Rezoning Transportation Analysis

Petition Number: 2023-147

Revision Log:

Date	Description
12-27-23	First Review (IW)
01-24-24	Second Review (IW)
02-19-24	Third Review (DR)

Rezoning Plan
 Charlotte NC 28212

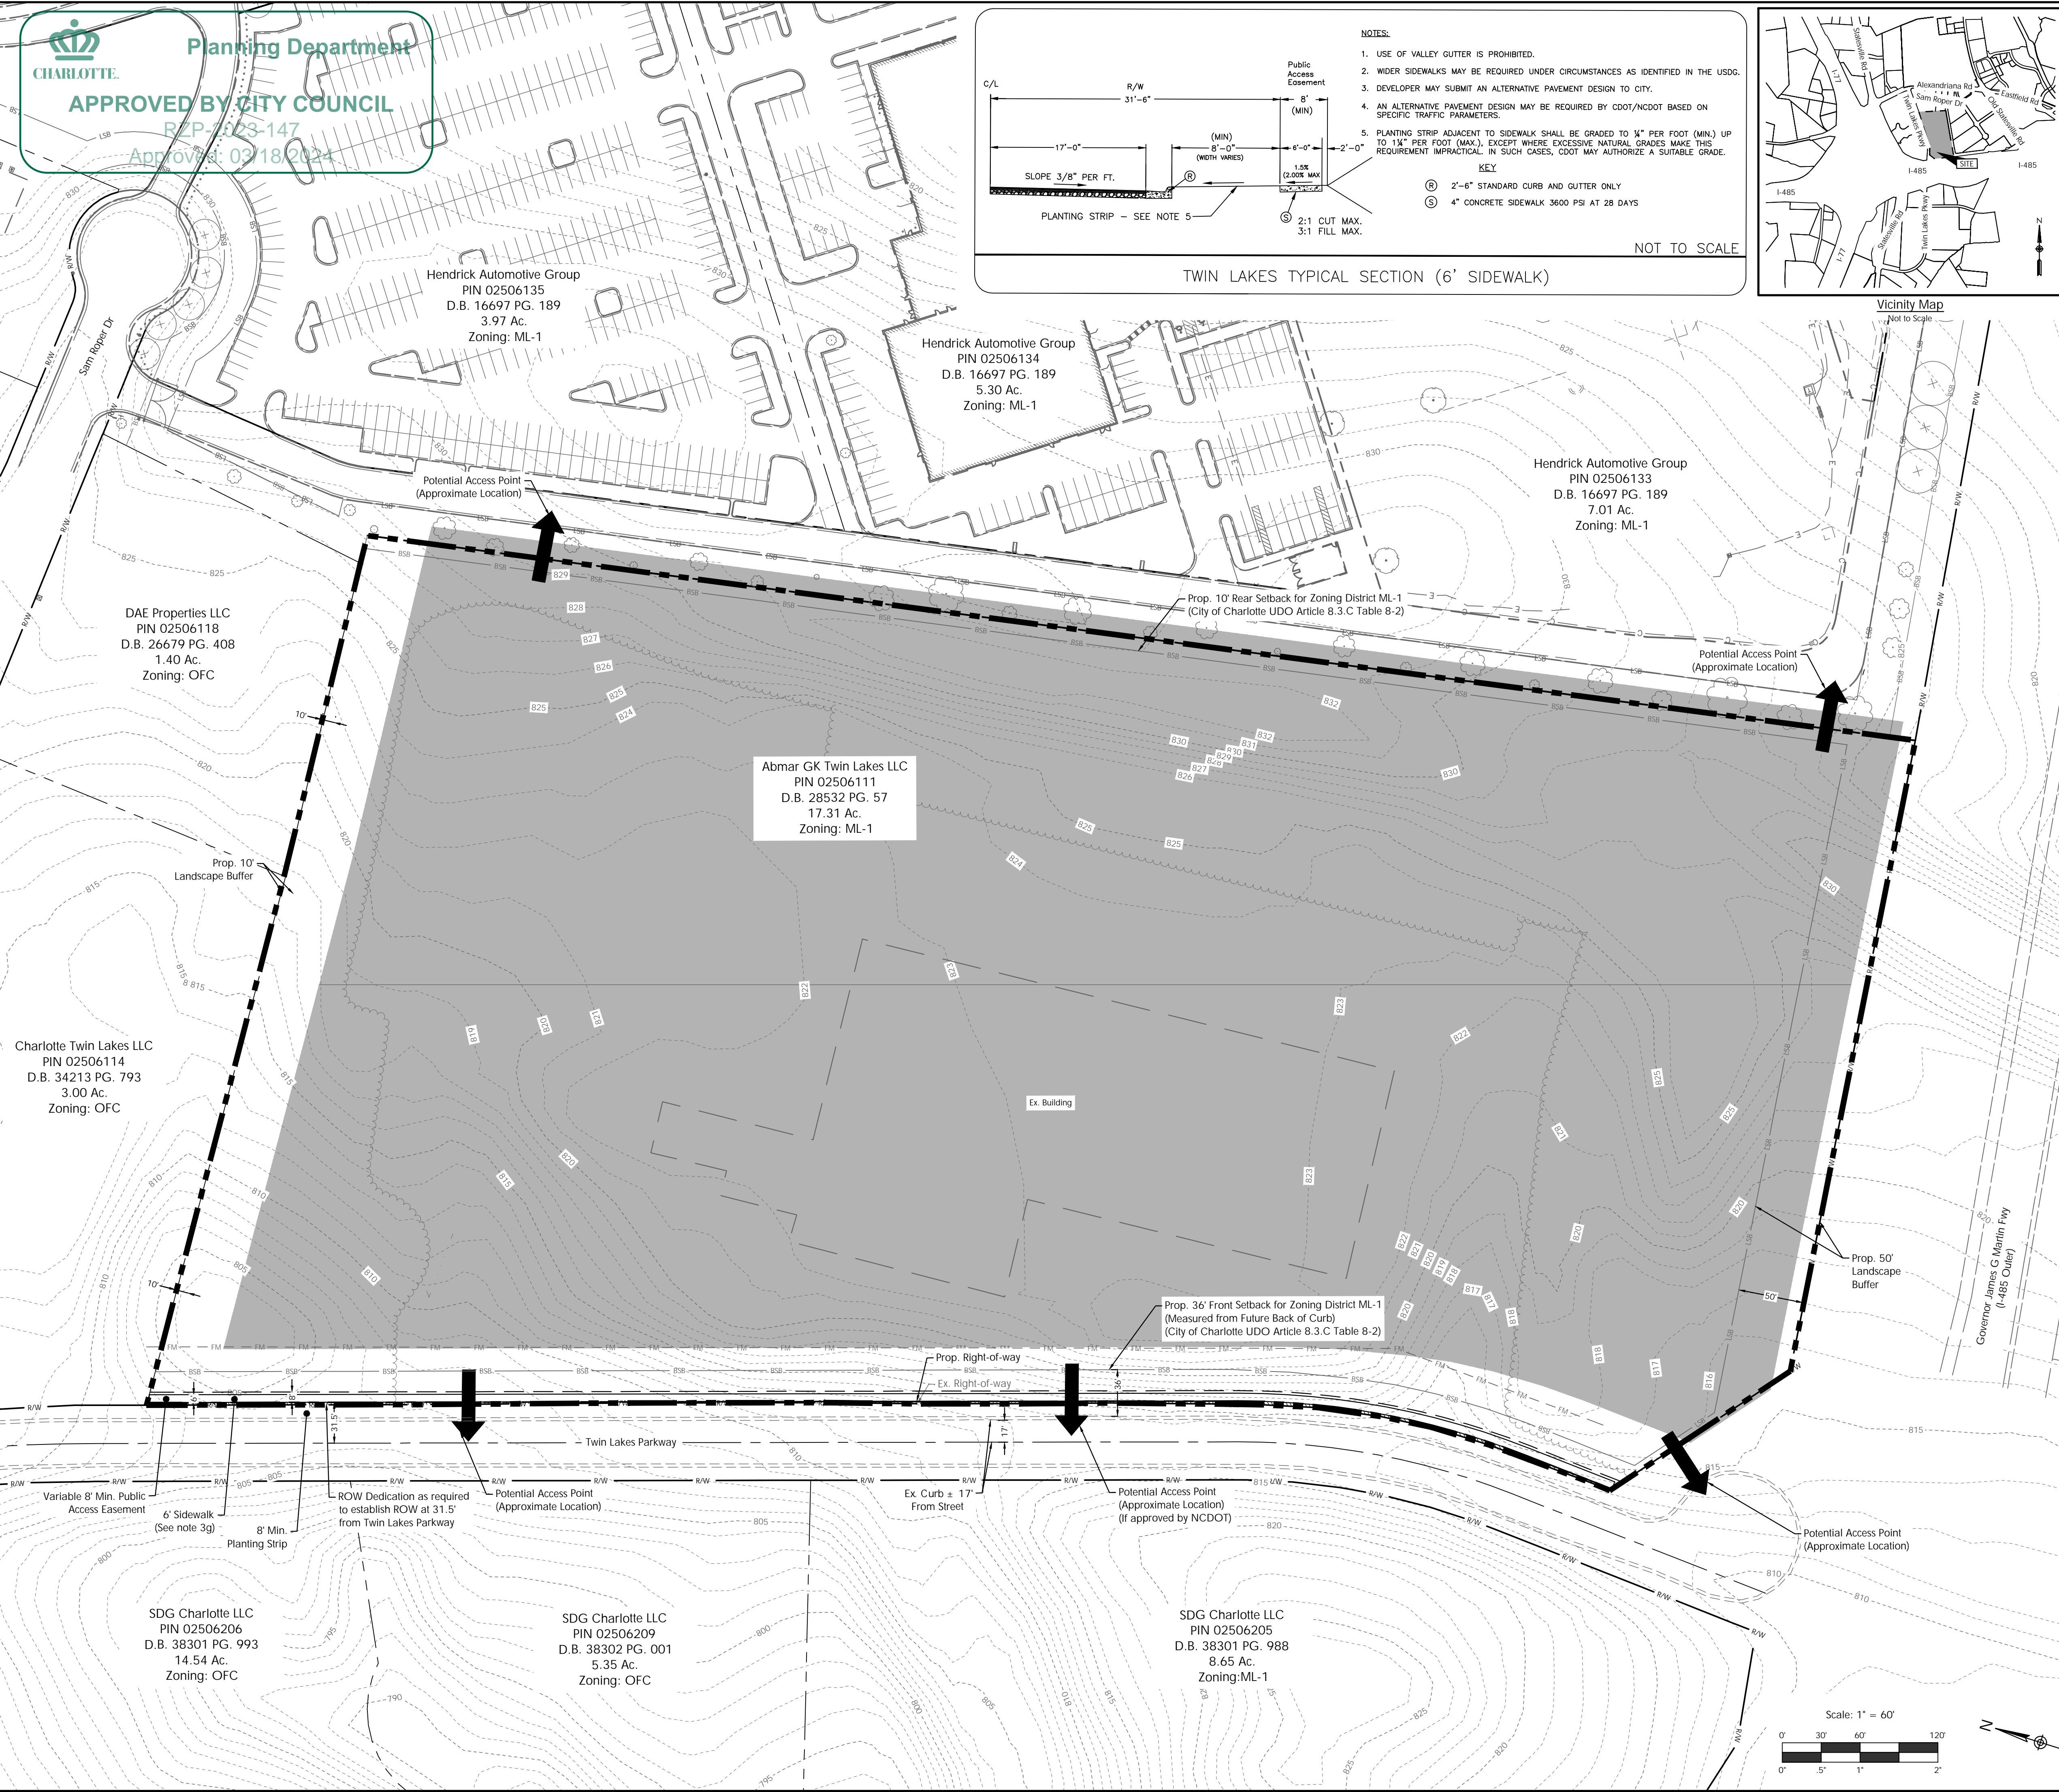
a. ~~Twin Lakes Parkway~~: Location of future curb and gutter is to be 17 feet from centerline.

CLDSM standard U-06 based on Table 33-2 in UDO

Label and dimension the curb and gutter from the centerline for each road on the site plan.

3. New Comment 1.25.24: Add density and land use information to the site plan.

- ~~4. Revise site plan and conditional note(s) to commit to dedicate 31.5 feet of right-of-way from the Twin Lakes Parkway road centerline. The site plan shall label and dimension the right-of-way from the road centerline.~~

- ~~9. Revise site plan and conditional note(s) to construct 8-foot planting strips and 6-foot sidewalks on Twin Lakes Parkway. The site plan shall label and dimension both items from the back of curb and gutter or edge of pavement. Add conditional note The entire facility must be outside of the right of way and within a public access easement. Add conditional note committing to construction and maintenance of the 6-foot sidewalks on Twin Lakes Parkway.~~
